Recommendation Report for Planning Permission for Works or Extension to a Dwelling

REF NO: M/2/21/HH

LOCATION: 45 Southdean Close
Middleton-On-Sea
PO22 7TH

PROPOSAL: Two storey front extension, first floor side extension, single storey side extension, two storey side extension, conversion of roofspace to habitable use with rear dormer and installation of 4 x balconies.

Drawing Title:
PROPOSED SITE PLAN

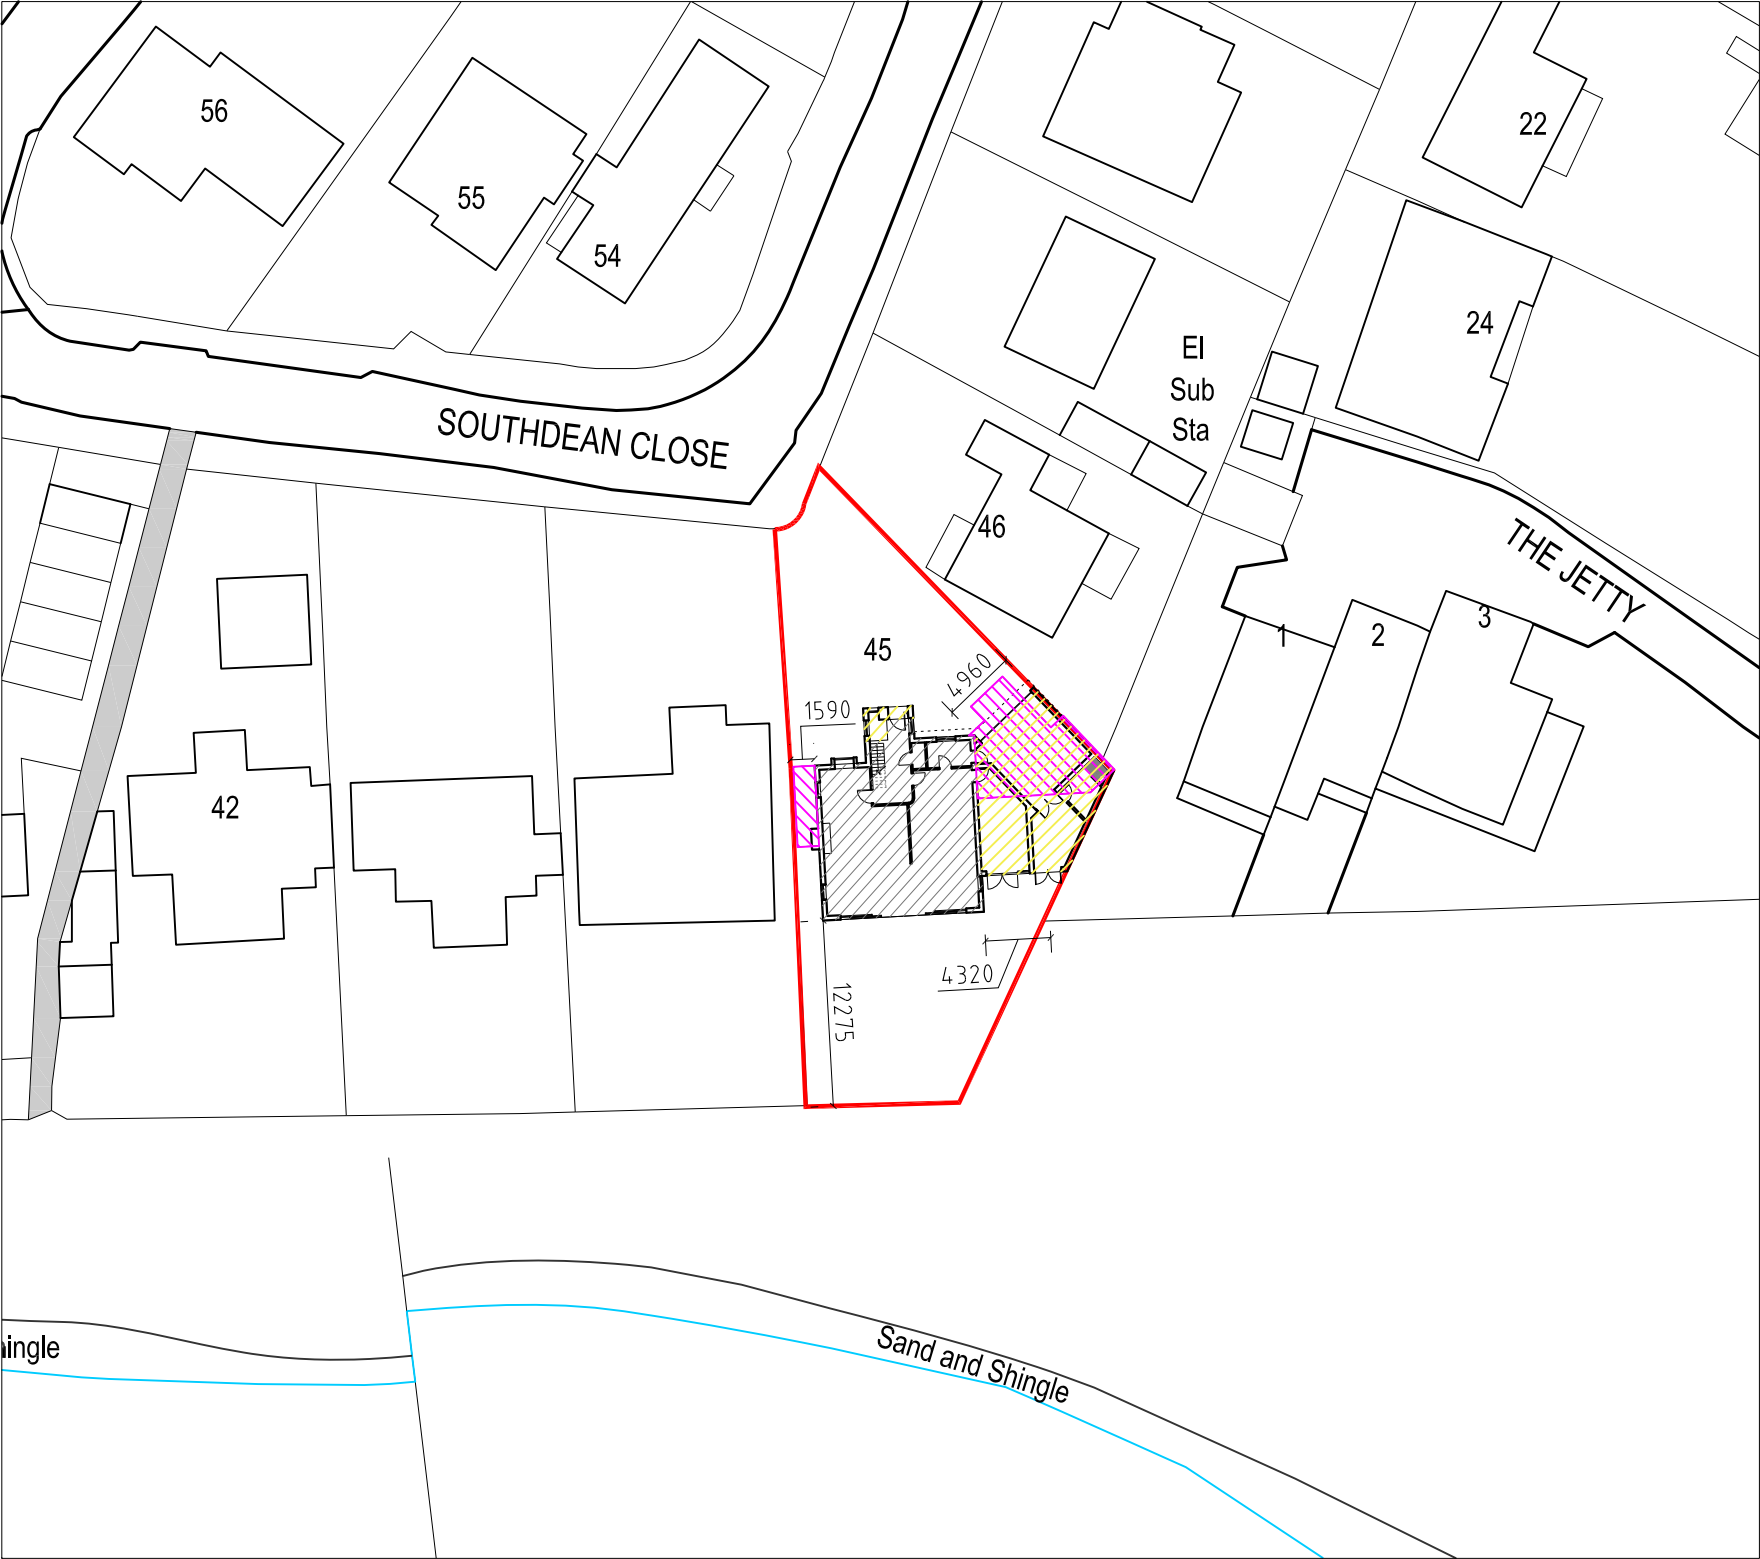
The large scale of this development had resulted in issues relating to the close proximity to the boundary, however substitute plans has now resolved this issue. Therefore, resulting in this development appearing subservient to and integrated to the existing dwelling.

This proposal sits at all elevations of the property and has a significant boundary at the north and south. At the north the proposal sits 11.57m to the boundary and at the south it sits 12.06m. At the east and west elevation the proposal sits at the boundary, at the west this looks to 44 Southdean Close and the east it looks to 1 The Jetty and 46 Southdean Close.

Drawing Title:
PROPOSED FLOOR PLANS & ELEVATIONS

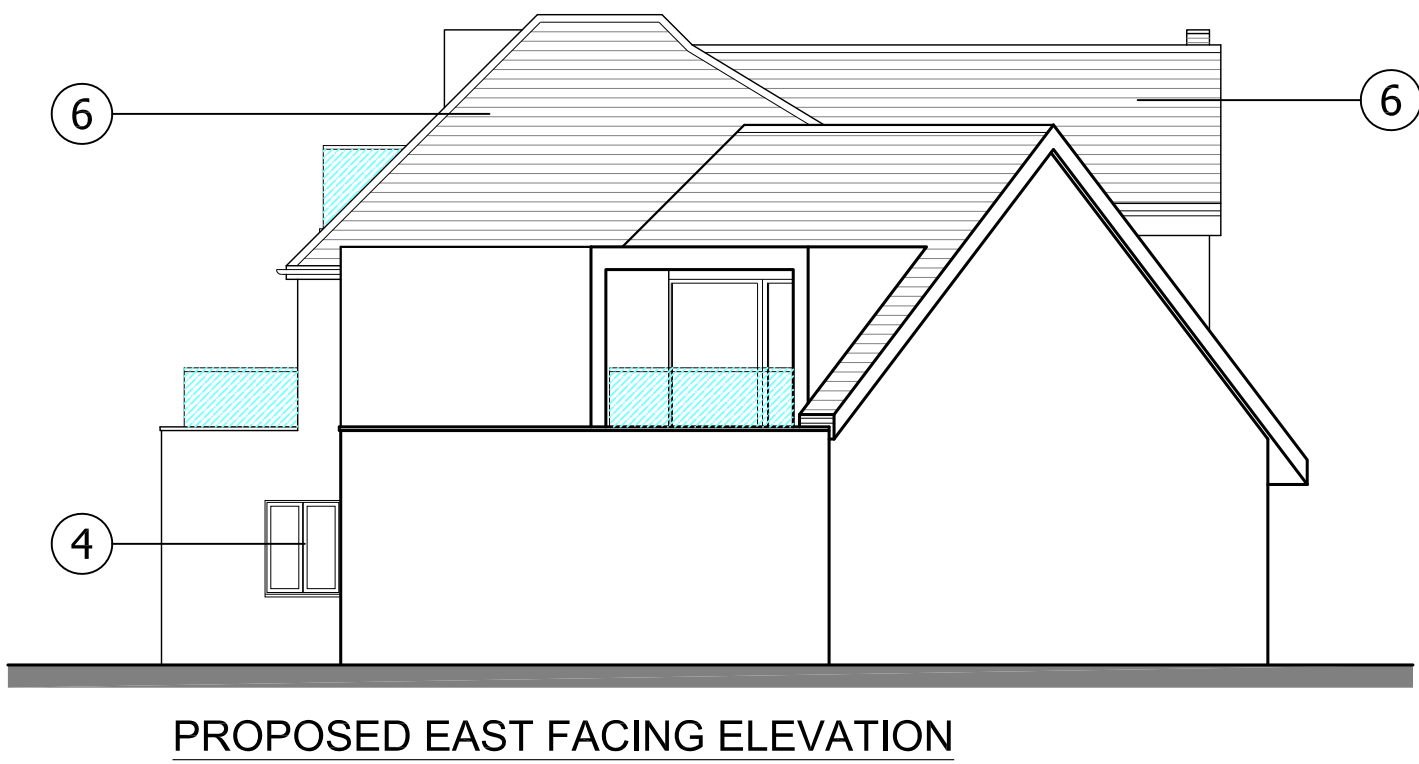
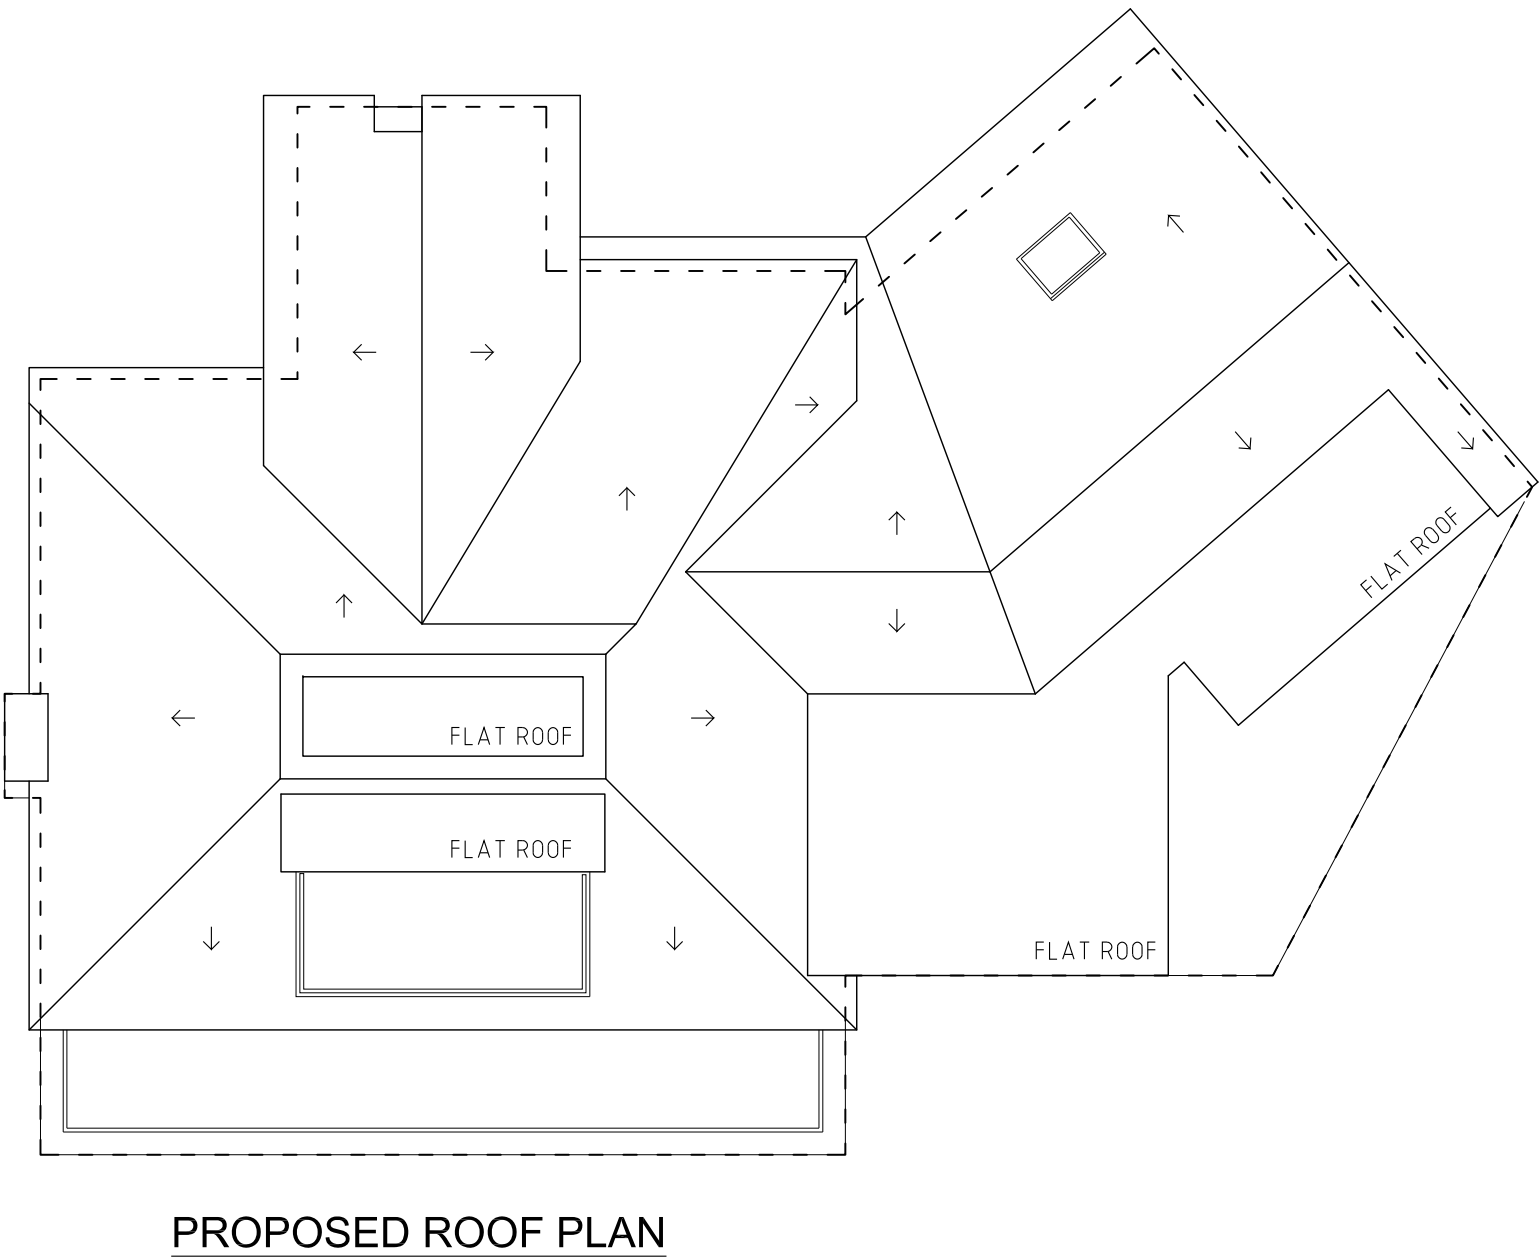
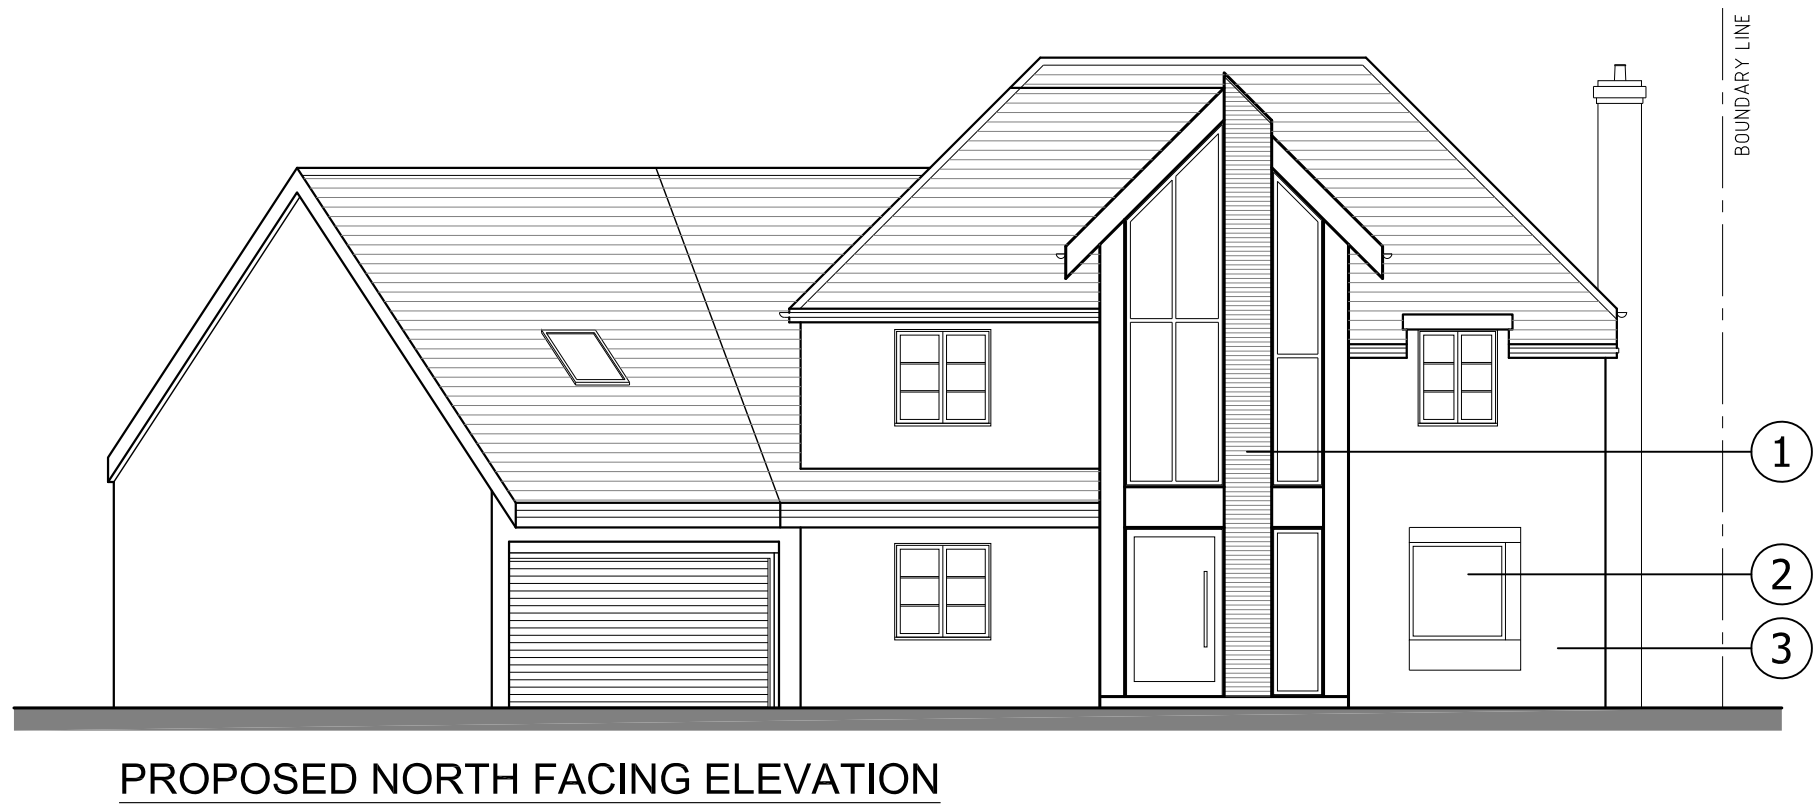
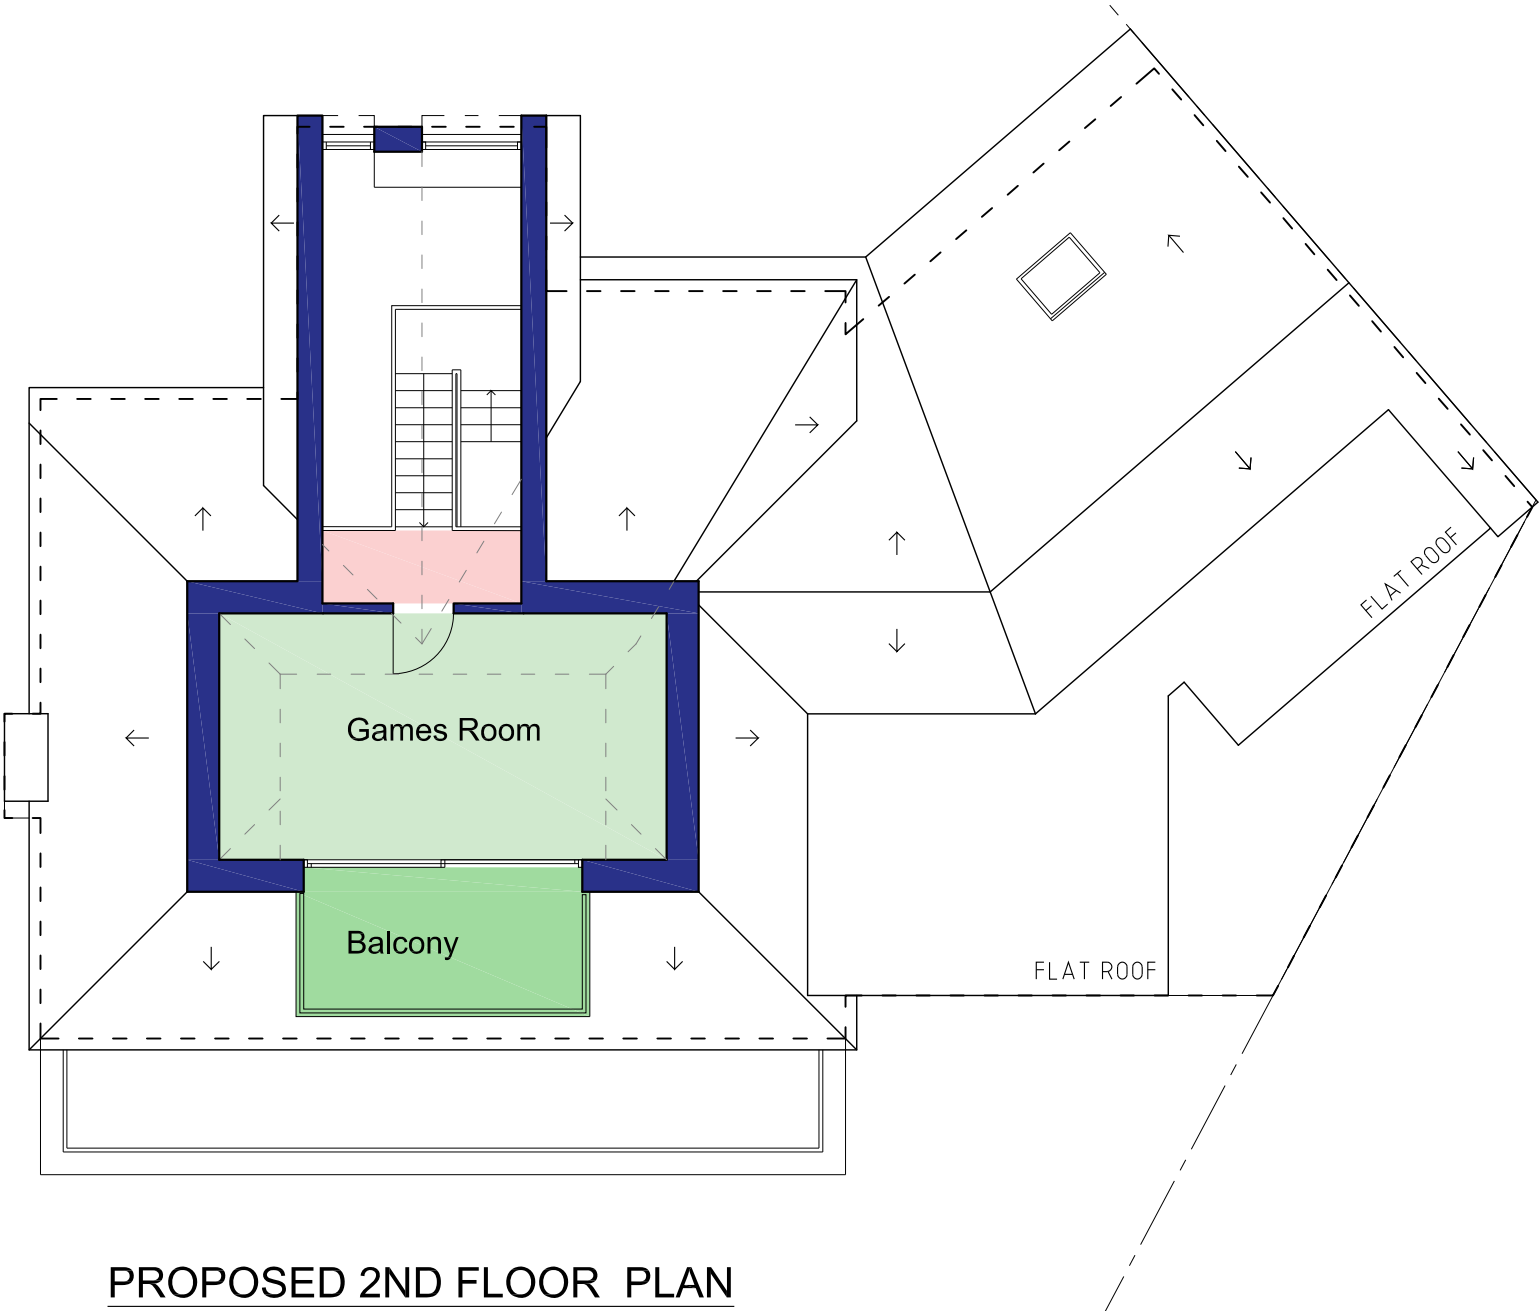
At the side elevations the proposal is for a first floor side extension, single storey side extension and two storey side extension. The proposal at the side (east) on these elevations will result in significant harm to the neighbour at the side, 1 The Jetty. This is due to the first floor extension with the addition of bedroom 4, the extension will result in sunlight being blocked to the private amenity space of 1 The Jetty, therefore having a harmful impact on this neighbour.

The balcony which leads out onto bedroom four will result in overlooking and overbearing effects to the 1 The Jetty to the east. This is due to the balcony being positioned on a first floor extension which looks out onto the rear garden on this neighbour. As a result, causing significant overlooking effects which results in this application being refused.

- 1 The extension due to its scale, design and close proximity to the boundary will have an oppressive and unneighbourly effect on neighbouring occupiers contrary to policies D DM1 and D DM4 of the Arun Local Plan.
